**Consultation Response from KC,
Highways Development Management**
2021/90219 5, Park Riding, Northgate, Honley, Holmfirth, HD9 6QL
**Erection of extensions and alterations to garage create dwelling forming annex
accommodation associated with 5, Park Riding, Northgate, Honley, Holmfirth, HD9 6QL**
Date Responded: 18/05/21 Responding Officer: ZT Responding Ref: 3-50-32

This application is at 5, Park Riding, Northgate, Honley, Holmfirth. The proposal is for the erection of extensions and alterations to the garage to create a dwelling forming annex accommodation.

Drawing Title
Parking and Bin Location
Comparison

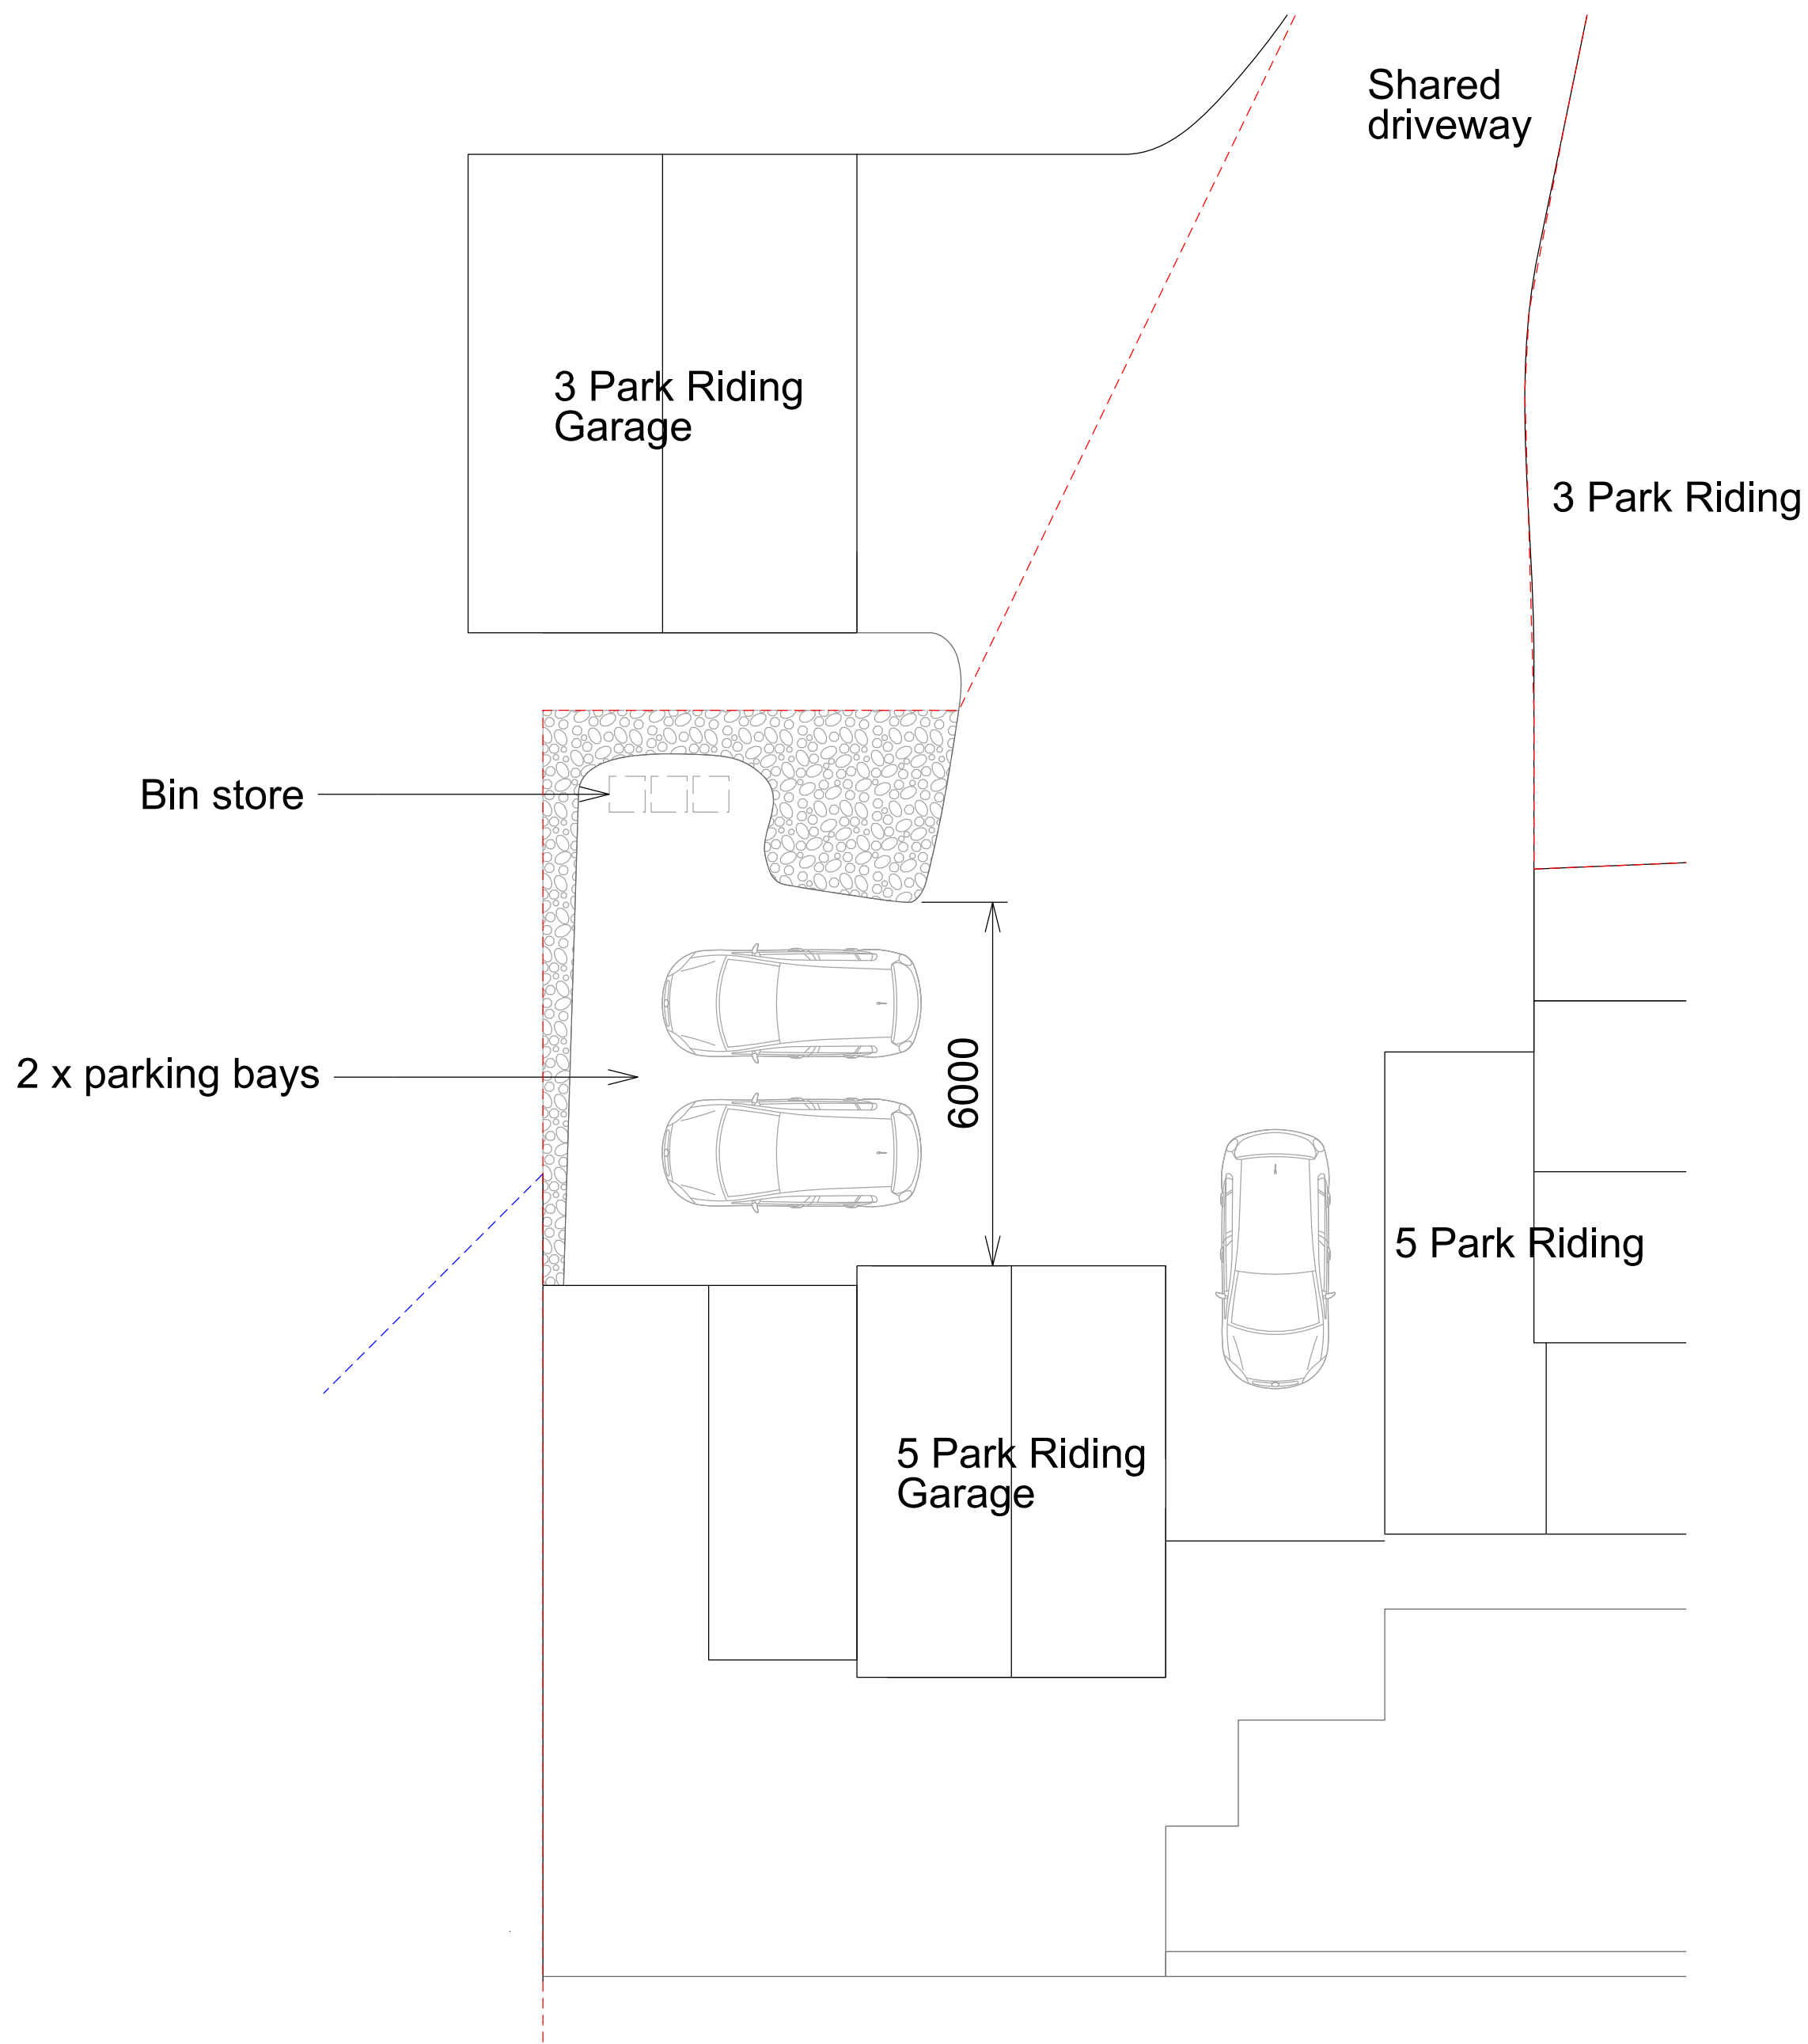
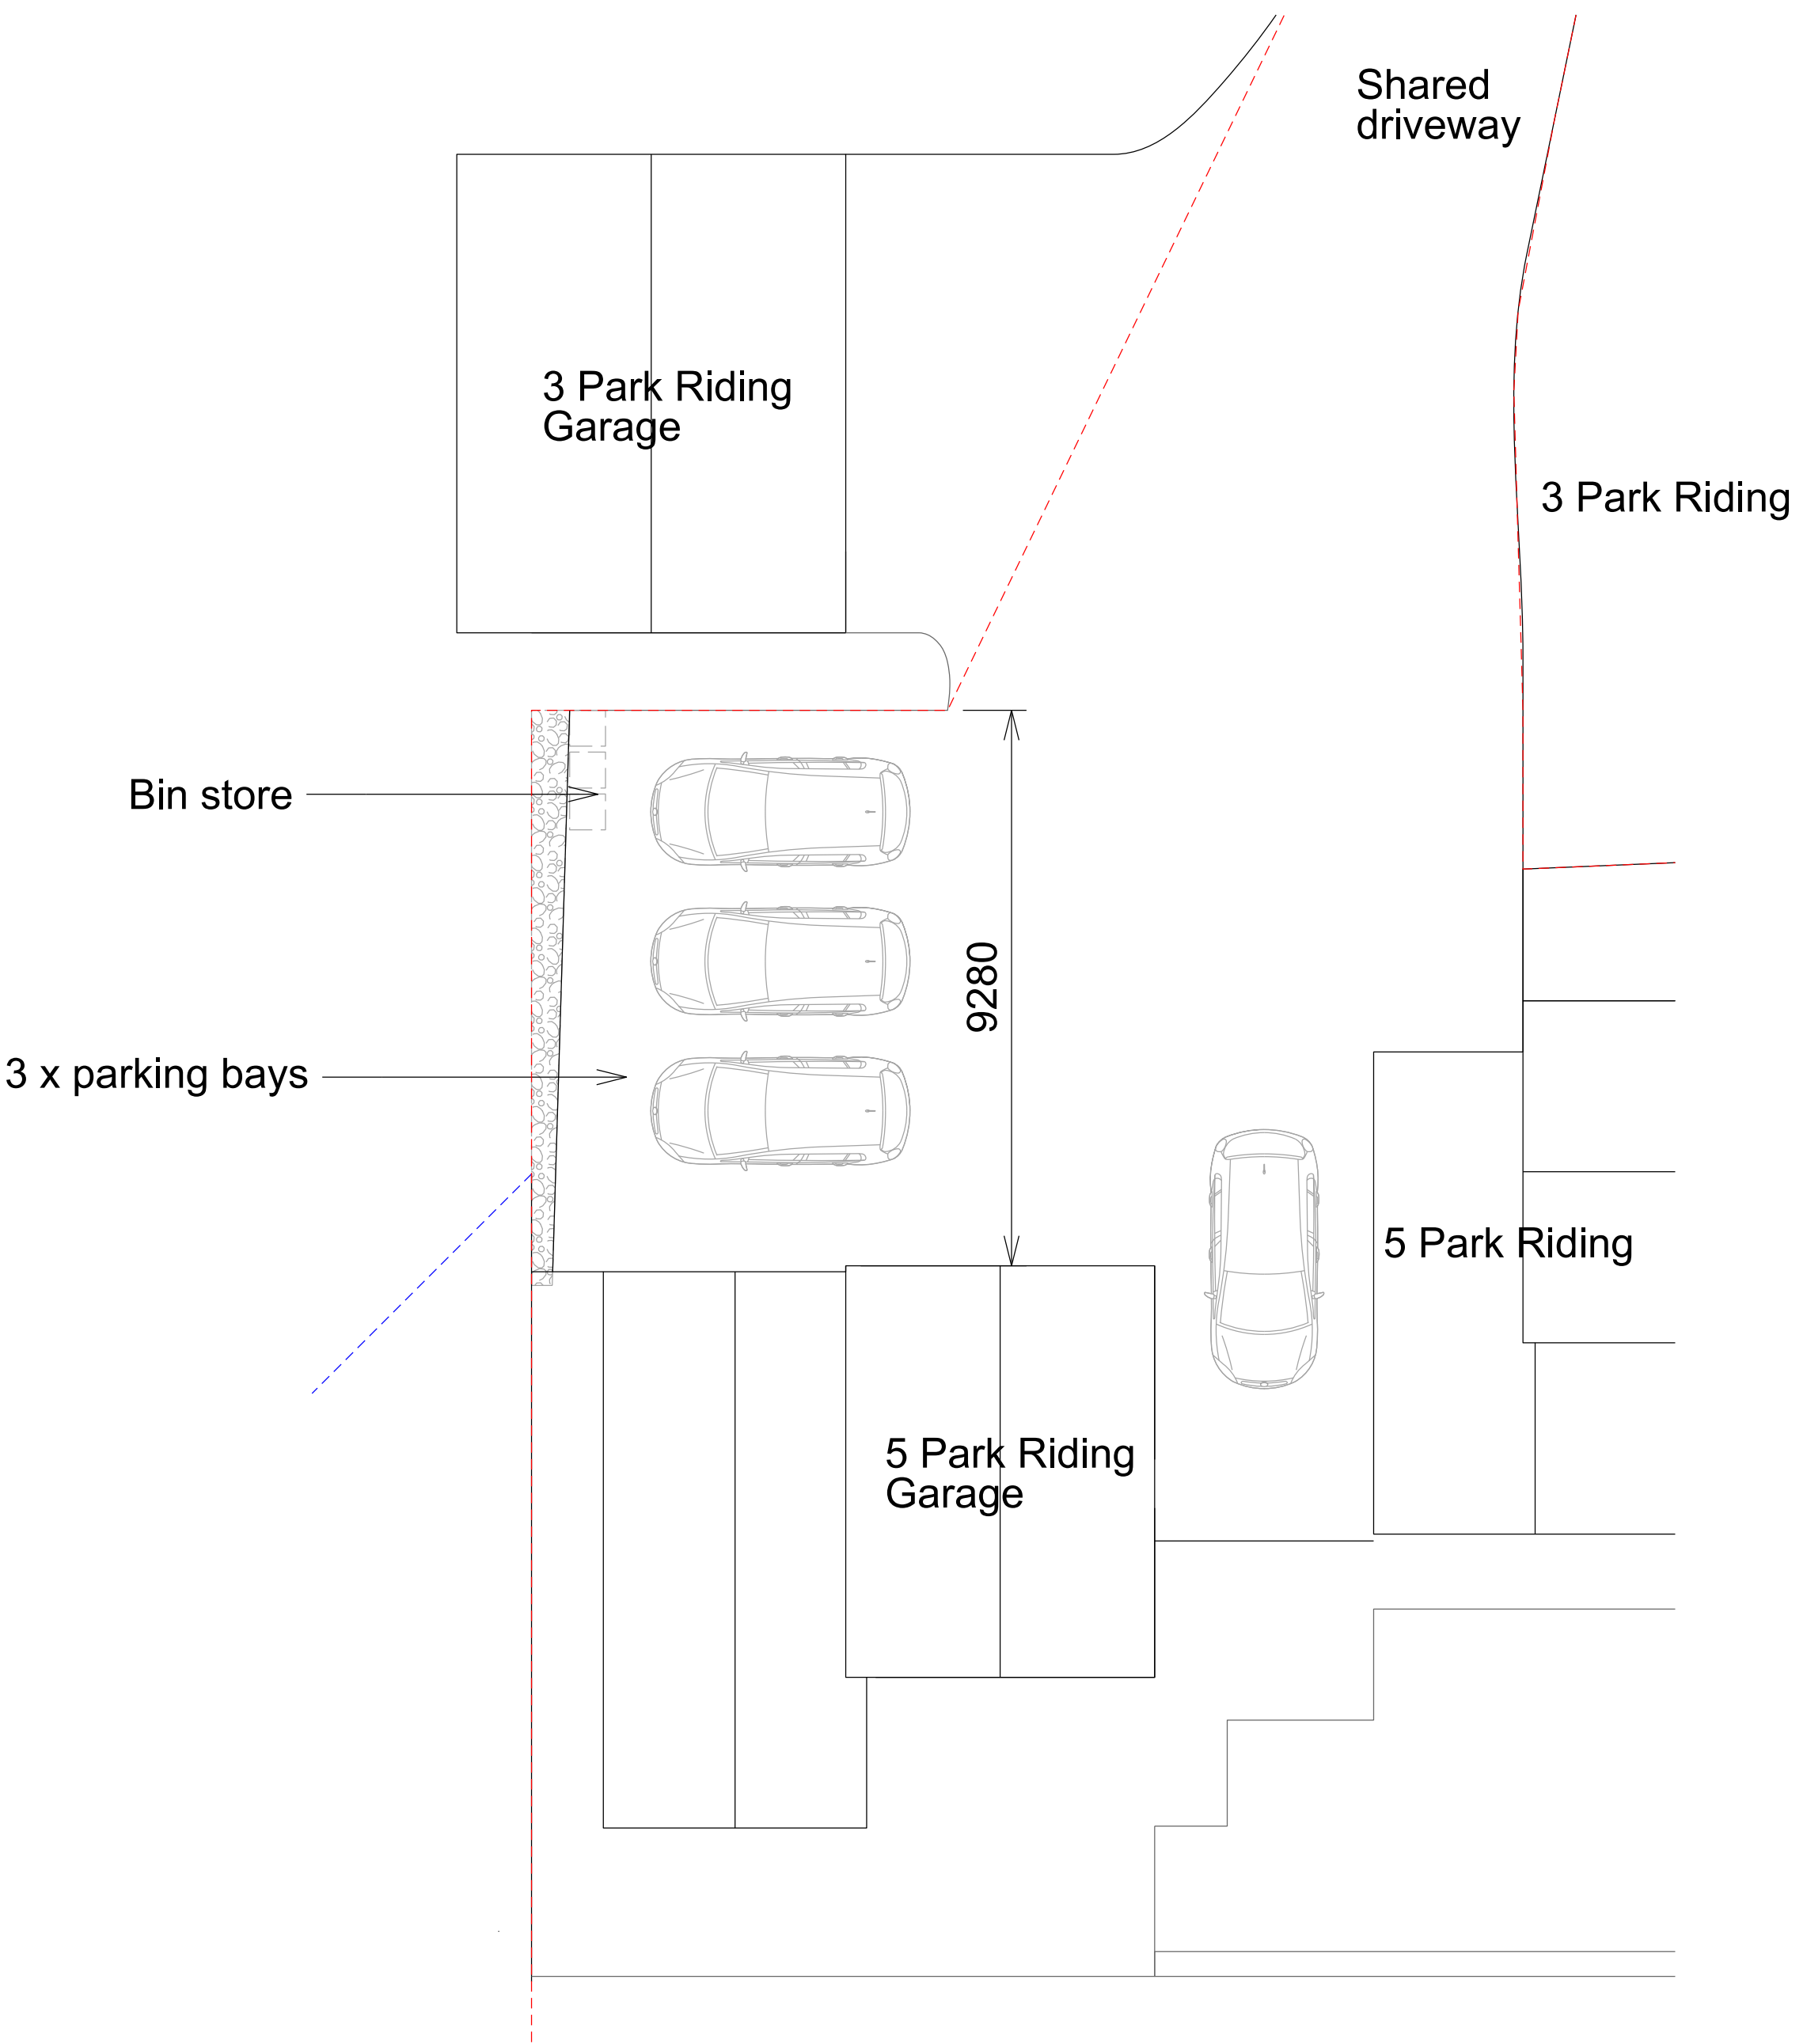
The site currently has 4 parking spaces although one is being lost due to the conversion of the garage however, for the host dwelling 2 parking spaces are sufficient due to them having 2 bedrooms.

The third parking space is adequate for the new annex and an additional fourth parking space is being formed by the bin store.

There is a sufficient gap between the 3 and single parking spaces to turn and exit the site in forward gear.

Bin storage has been presented in a suitable location by the parking area.

Highways Development Management consider sufficient parking is provided for both the existing dwelling and new annex so therefore the application is acceptable with the following conditions.
